IN THE MATTER OF AN APPLICATION FOR DEVELOPMENT CONSENT IN  
RESPECT OF STONESTREET GREEN SOLAR FARM PINS REF EN010135

COUNSEL'S NOTE

1. I provide this note for the Aldington and Bonnington Parish Council in connection with the commencement of the Examination of the Stonestreet Solar Development Consent Order Application (“Application”). I deal briefly with the stage that we have reached in the procedure, and then provide my initial comments on the draft Development Consent Order itself (“dDCO”).
2. I note at the outset that I have been instructed by another party to advise in relation to the Application which has given me some background information about the Application. I do not consider that there is any conflict of interest in advising the Parish Council on this limited set of instructions.

- Key:
- Order limits
 - Work No. 1
 - Work No. 2
 - Work No. 5
 - Work No. 6
 - Work No. 7
 - Work No. 8
 - 1-29 Field Number

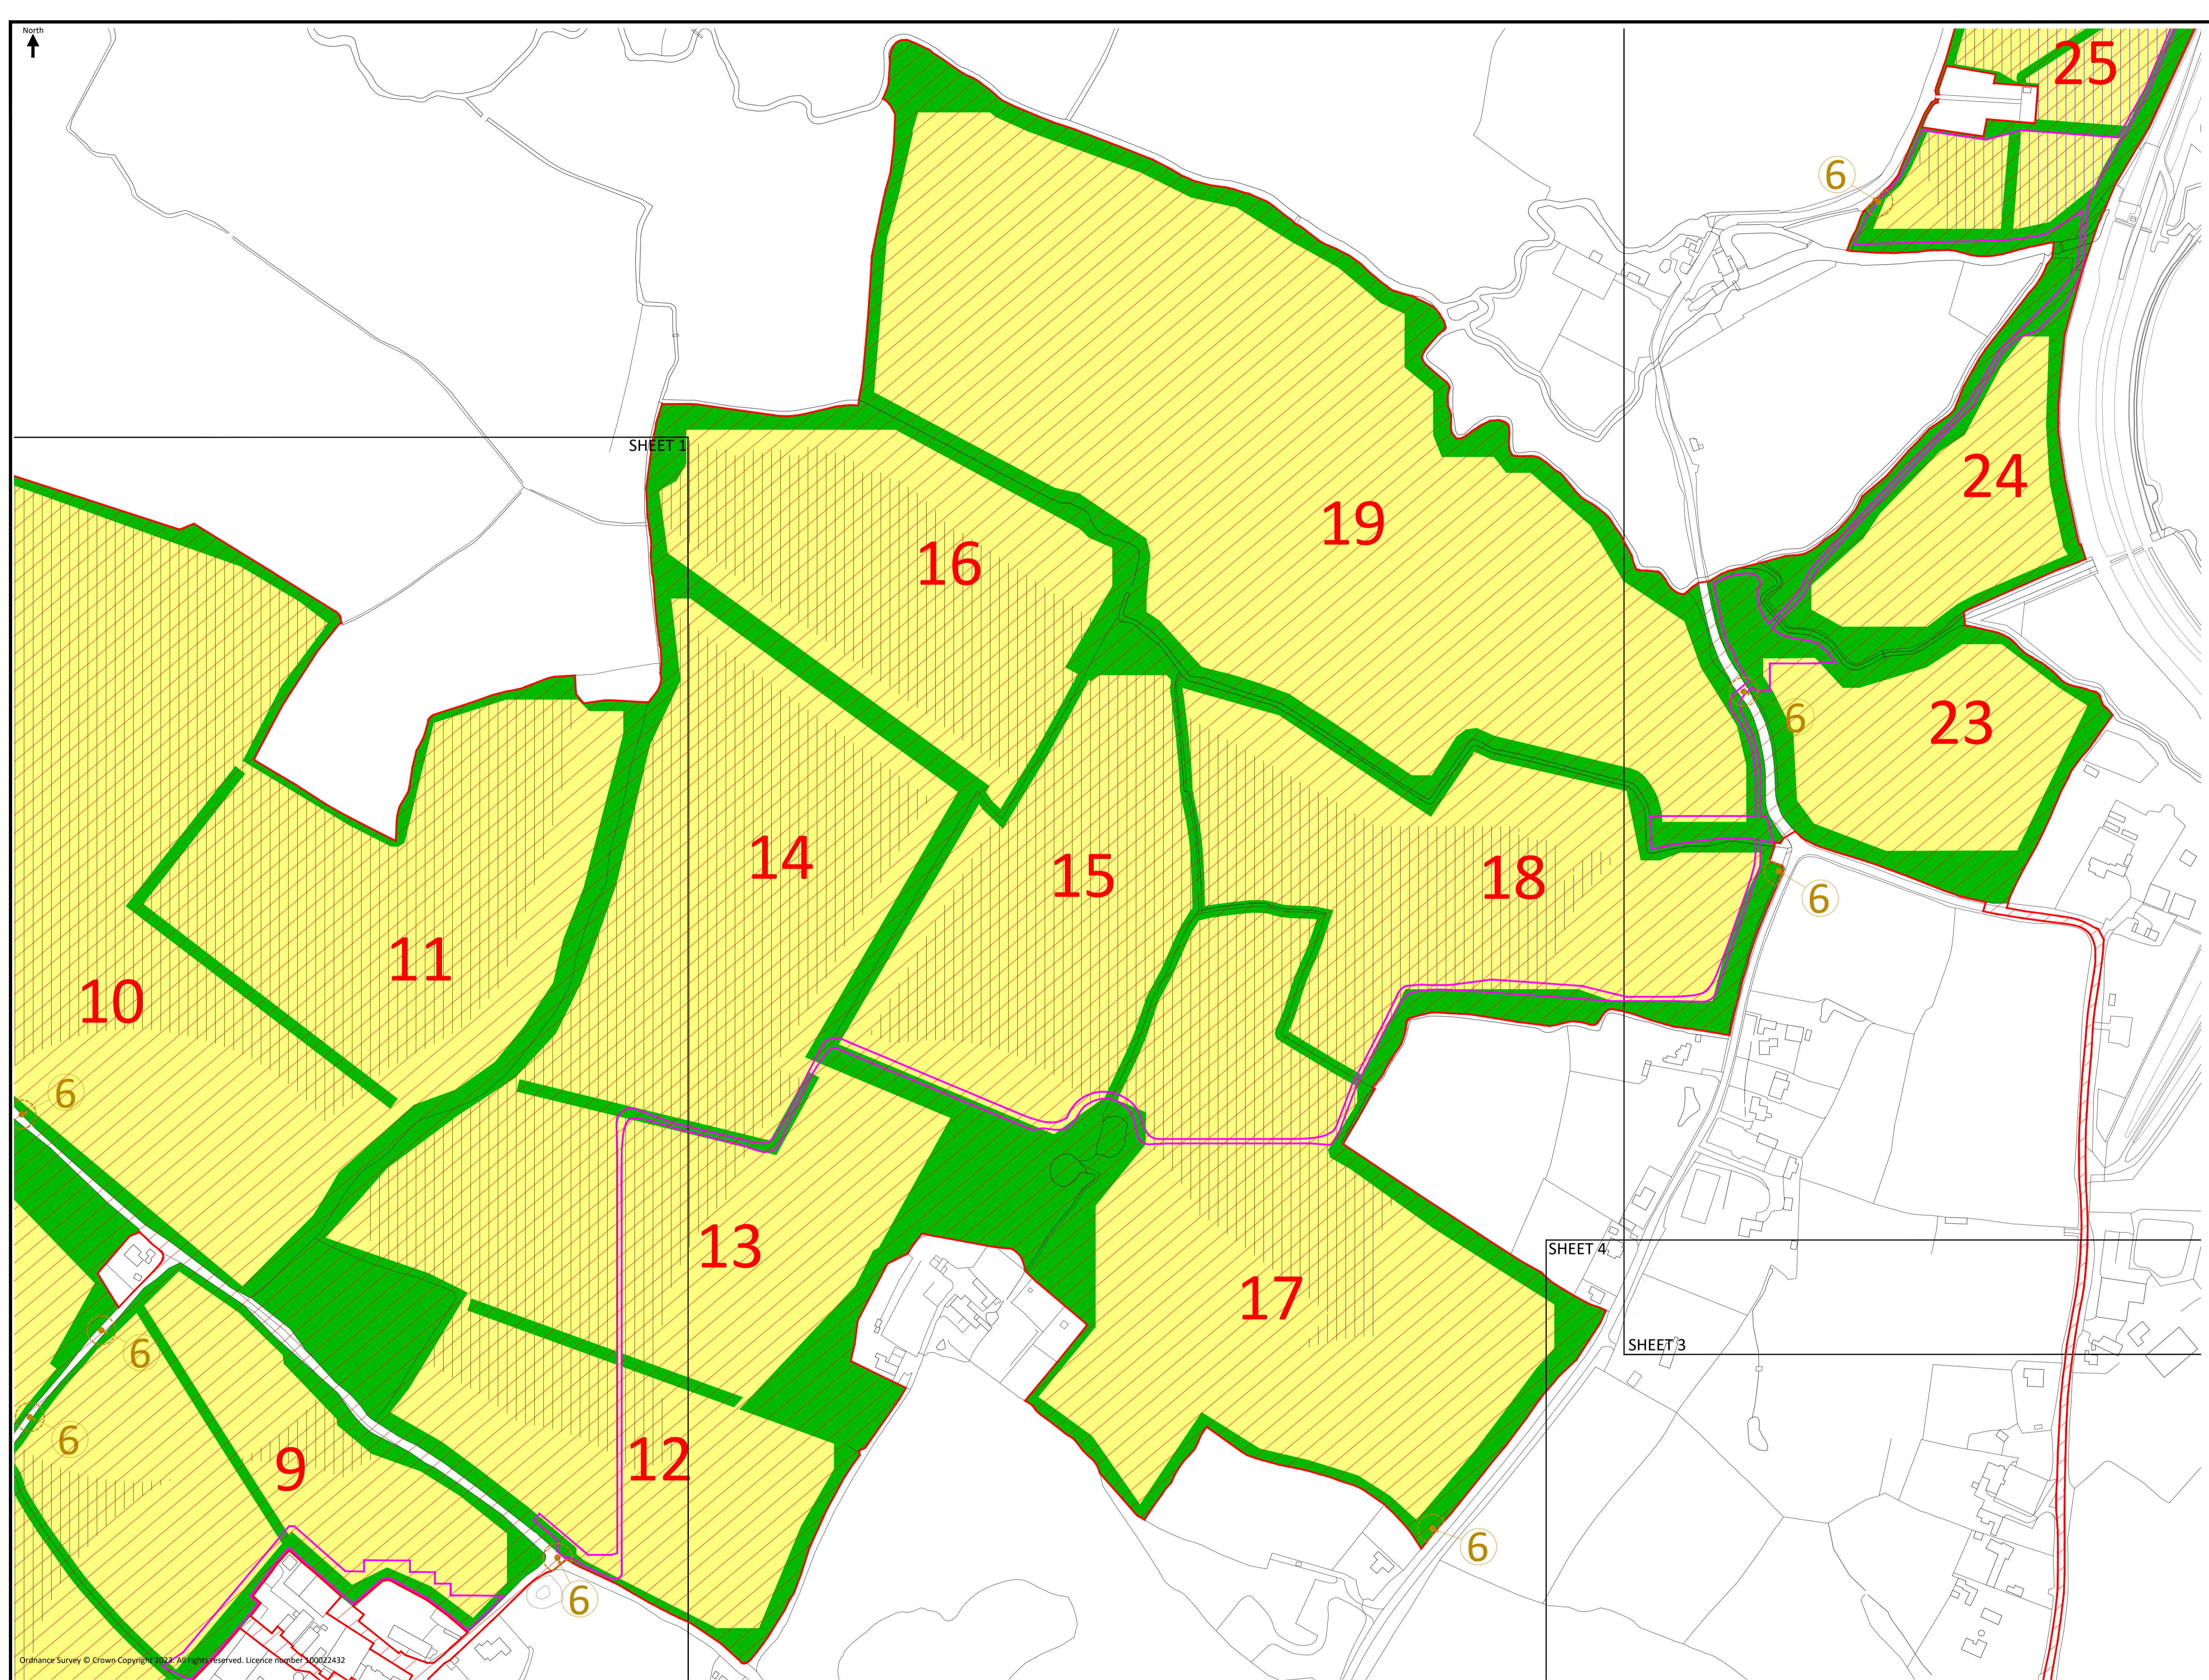
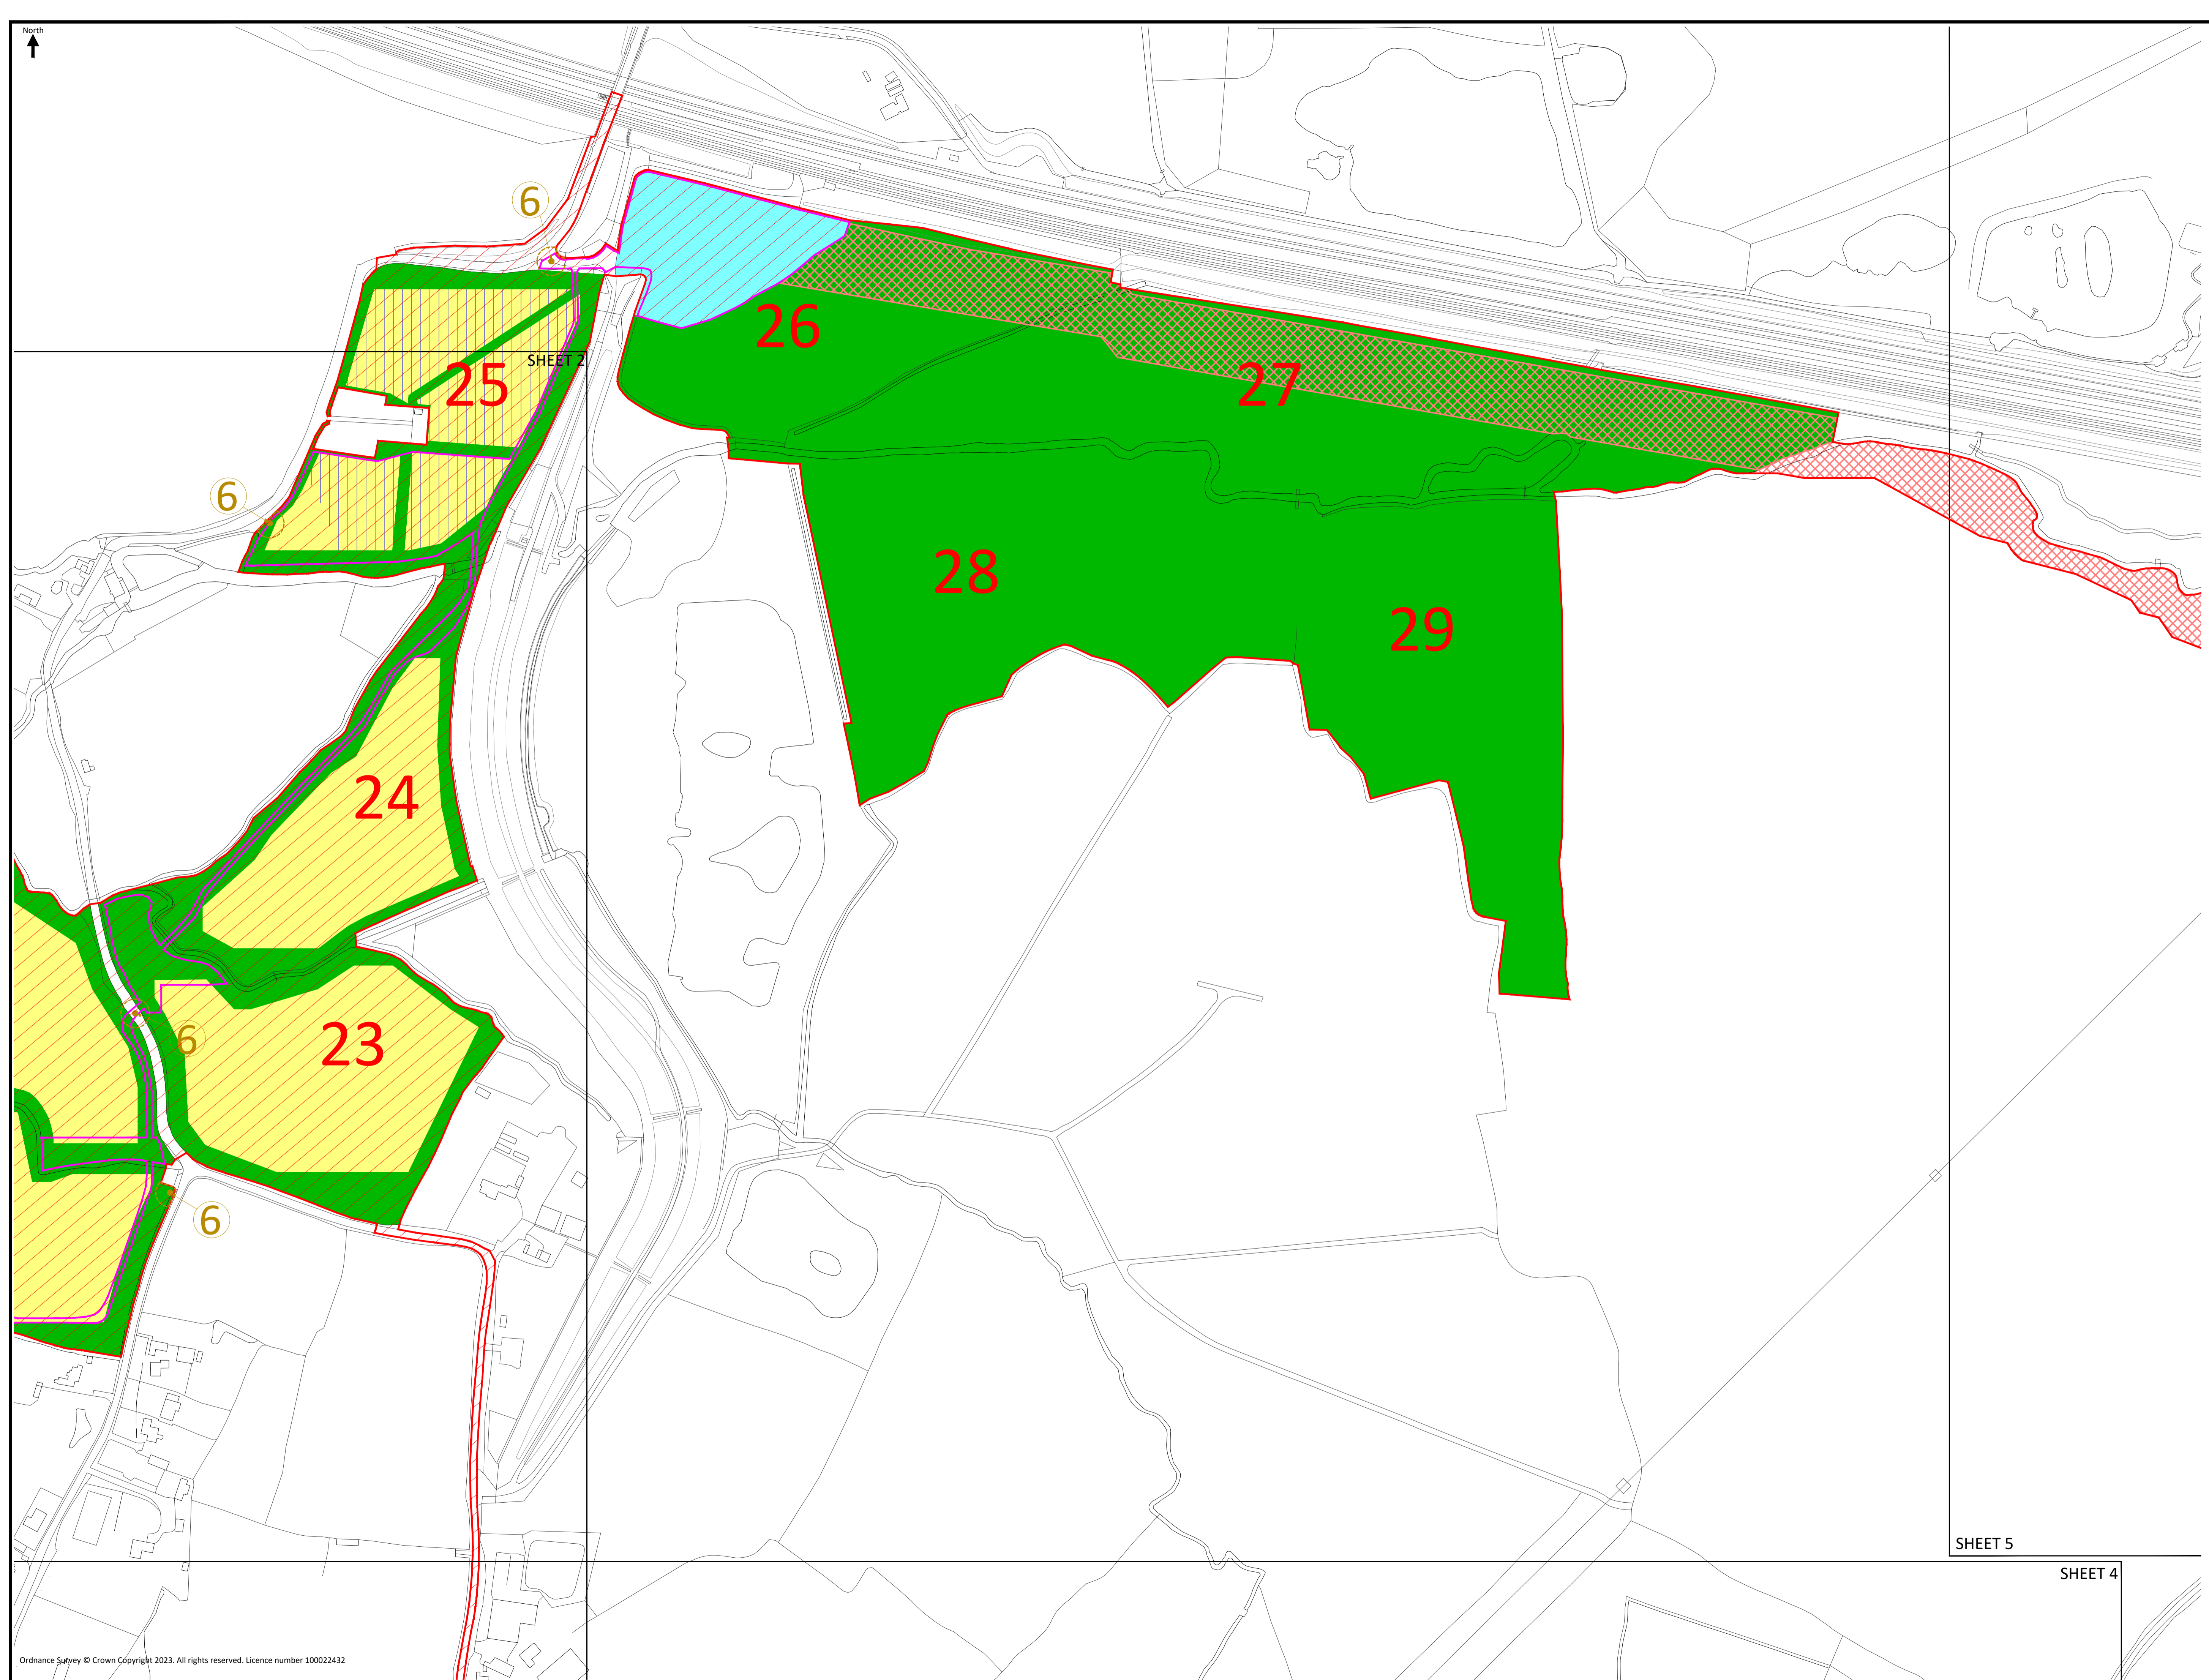
11. This is important, as the Work Plans which accompany the dDCO are incredibly generic about the location of key elements of the scheme, merely providing an indicative hatching across most of the site for both the solar array (Work 1) and the battery component of the scheme (included within Work 2).

14. Secondly, given that there is no number of or approximate locations for the battery storage and connected elements of the scheme, I find it difficult to understand how the Rochdale envelope can be robustly created – is the Applicant going to assume as a

worst-case scenario that *all* the land hatched on the Work Plans for Work 2 will be occupied by batteries and their infrastructure? That would on one level be absurd, but on another, if there is an unlimited number of batteries permitted across that whole area, then that is what the Rochdale envelope requires to be assessed.
